TREE CONSULTATION RESPONSE

Application No	2025/0302
Proposal	Remove Ash trees T2 and T4 and remove epicormic growth from Lime trees T24 and T26 within TPO 1/1951.
Address	Cawthorne Cricket Club, Dark Lane, Cawthorne, Barnsley, S75 4HA.
Date of Consultation Reply	22/05/2025
Consultee	Edward Jowett (Tree Officer)

# Tree Plan

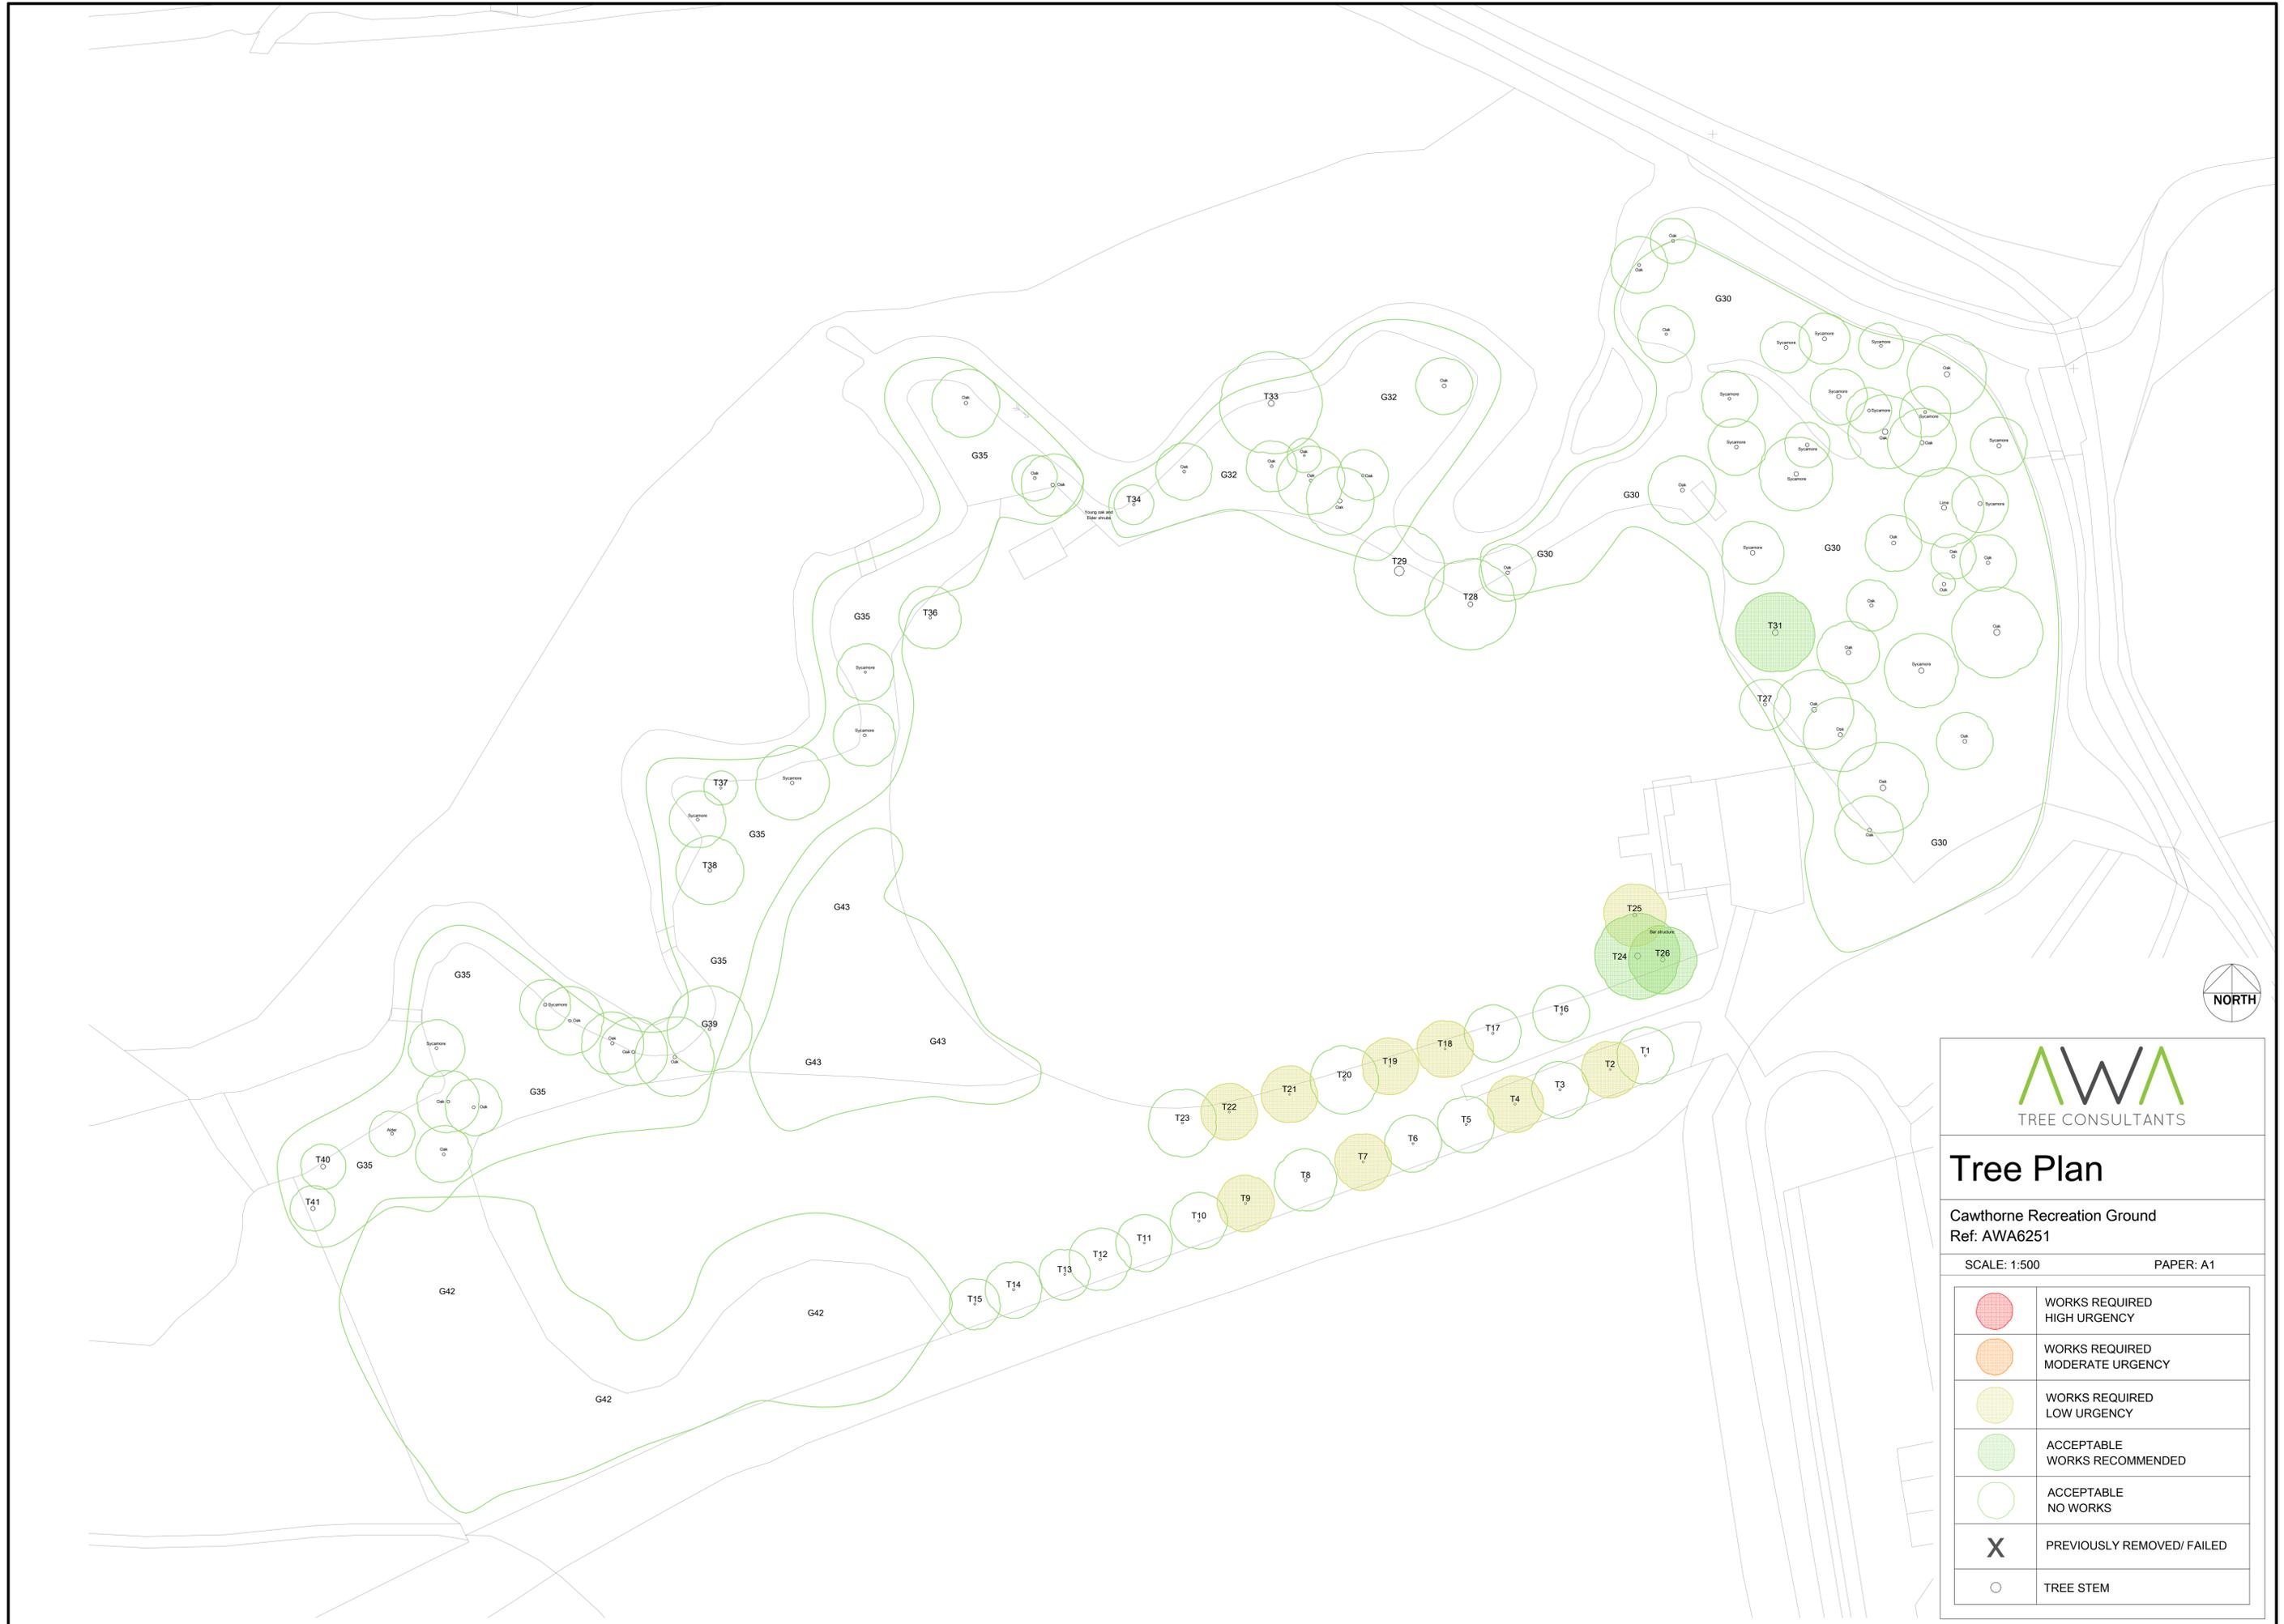
The two Ash trees to be removed are both medium sized specimens which form part of a longer avenue of trees and as such have significant amenity value. The two Lime trees are both large, mature, prominent specimens located in a high profile location close to the club house and as such these trees have high amenity value.

The works proposed are to remove the two Ash trees due to Ash dieback disease along with other more minor defects. Ultimately the presence of the disease makes the retention of the trees untenable, particularly with regards to the high footfall area in which they are located. These trees will need to be replaced, however like for like replacement is not currently an option or indeed sensible. As such I have conditioned Hornbeam to be used as they will ultimately reach a similar stature to Ash trees.

The removal of the epicormic growth from Lime trees T24 and T26 is only very minor work which is considered sensible and acceptable.

The tree report notes several trees which require deadwood removing, however the removal of deadwood does not require permission and as such cannot be considered as part of this application.
